**DELEGATED DECISION FOR APPLICATION FOR CERTIFICATE OF
LAWFUL DEVELOPMENT**

Reference no.: 2026/CL/90882/W

Site: 80, Blagden Lane, Newsome, Huddersfield, HD4
6JZ

Description: Certificate of lawfulness for proposed erection of
single storey side extension

west elevation

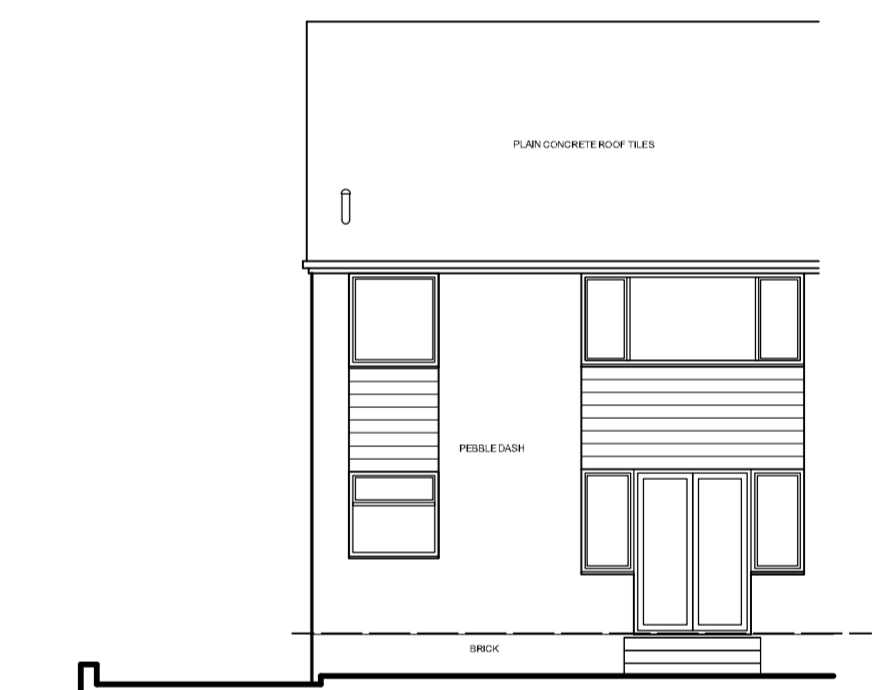
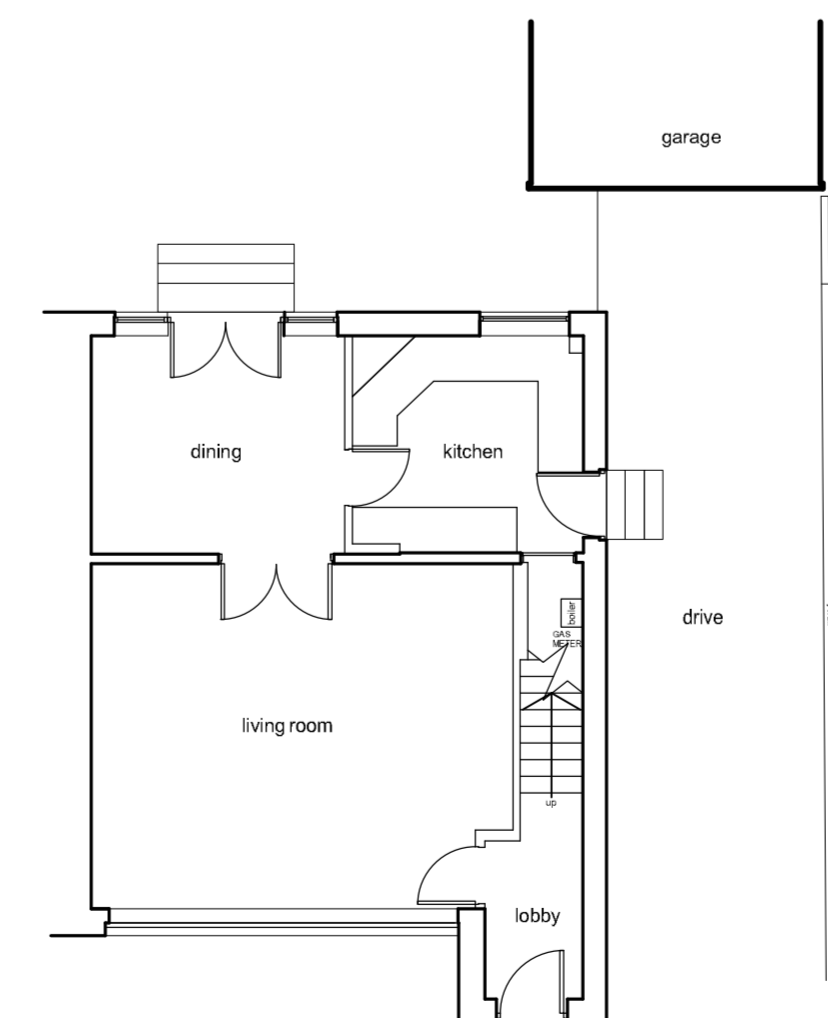
The proposed extension/enlargement would be set back from the front elevation by 5.7 metres lying flush with the existing rear elevation of the property. The extension/enlargement would project to the side by 2 metres with an eaves height of 2.9 metres and overall height of 3.9 metres.

It is proposed that extension/enlargement would be accessed via external steps.

Comment: *The height of the enlargement would not exceed the highest part of the roof of the existing dwellinghouse.*

Comment: *The height of the eaves of the enlargement would not exceed the height of the eaves of the existing dwellinghouse.*

Comment: *The enlarged part of the dwellinghouse would have a single storey. It would not extend beyond the rear wall of the original dwellinghouse or exceed 4 metres in height.*

Comment: *The enlarged part of the dwellinghouse would be within 2 metres of the boundary of the curtilage of the dwellinghouse however the height on the eaves of the enlarged part would not exceed 3 metres.*

Comment: *The enlarged part of the dwellinghouse would extend beyond a wall forming a side elevation of the dwellinghouse. It would not exceed 4 metres in height, would not have more than a single storey and would not have a width greater than half the width of the original dwellinghouse.*

Comment: *None of the above are shown on plan. However, it is proposed that a small external staircase would be relocated to facilitate access into the single storey extension. Whilst a raised platform would be created, this would not provide any 'meaningful' raised platform or balcony accommodation due to its limited size and provides external access to the curtilage of the dwellinghouse, Under these circumstances, the works solely to provide access to the dwellinghouse are not considered to fall under the definition of a development.*
